Martin Nugent
01254 828060
D3/11/0565

**Planning Application, Ribble Valley District
3/11/0565 SOAR Design, 1-5 Wesleyan Row, Clitheroe**

Drawing Title
PROPOSED PLANS AND ELEVATIONS

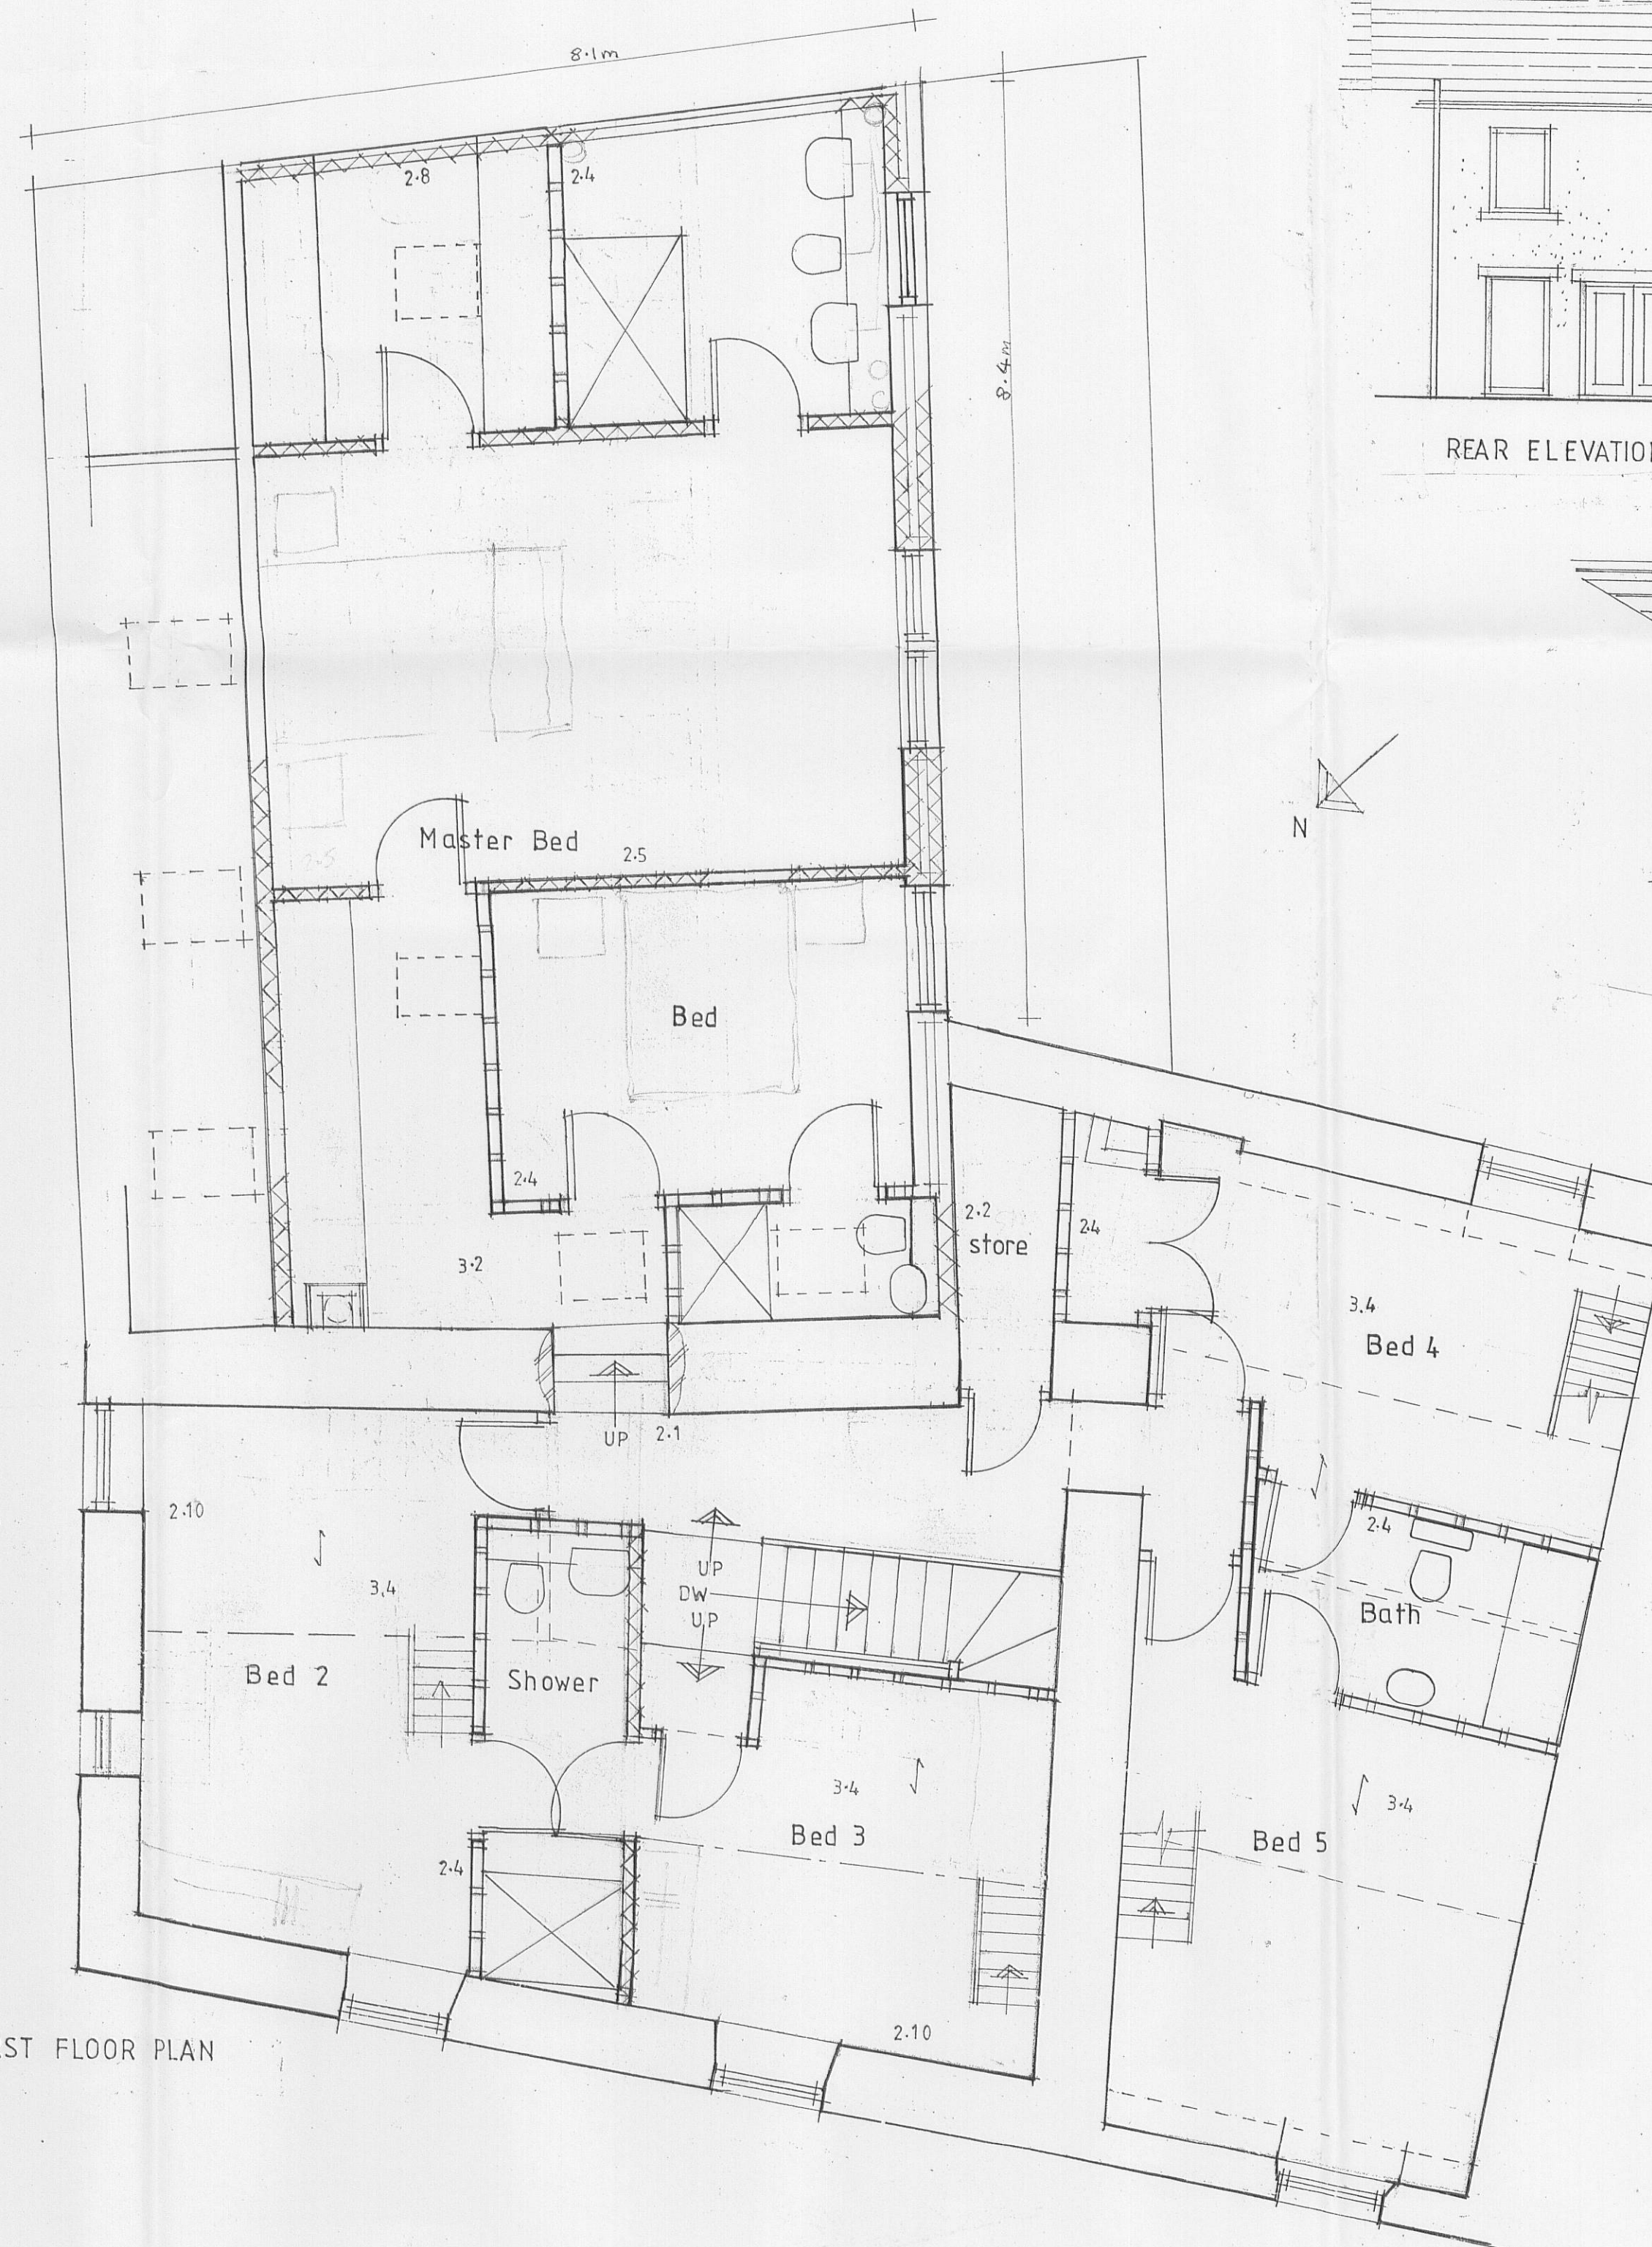
Further to my previous comments, the integral garage space has been omitted from the design. As this removes the issue of my previous highway safety concerns regarding the accessing of this feature, I have no objection to the development.
